DRB Comments

ITEM # 8

PROJECT # 1008022

RE: Lots 23 & 24, Block 42, Raynolds Addition

REPLAT OF

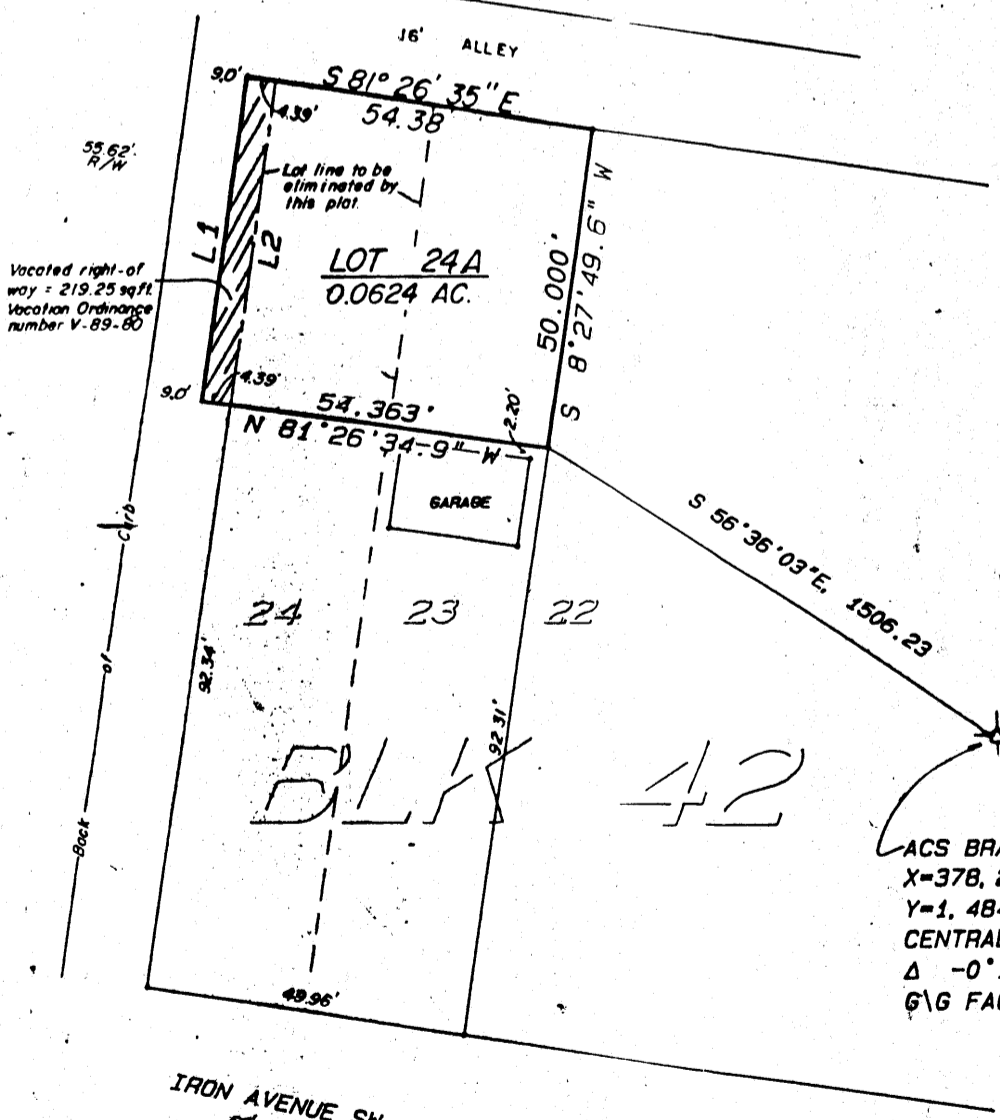
The request would be for a vacation of right-of-way (not an easement). If approved, the vacated right-of-way would have to be acquired from the City through the Real Property Division of the Legal Department, and replatted into these lots within one year.

It would seem reasonable to reasonable to vacate a similar width on 12th Street as was done to the north – refer to comments from Transportation Development regarding vacation of right-of-way on Iron Avenue.
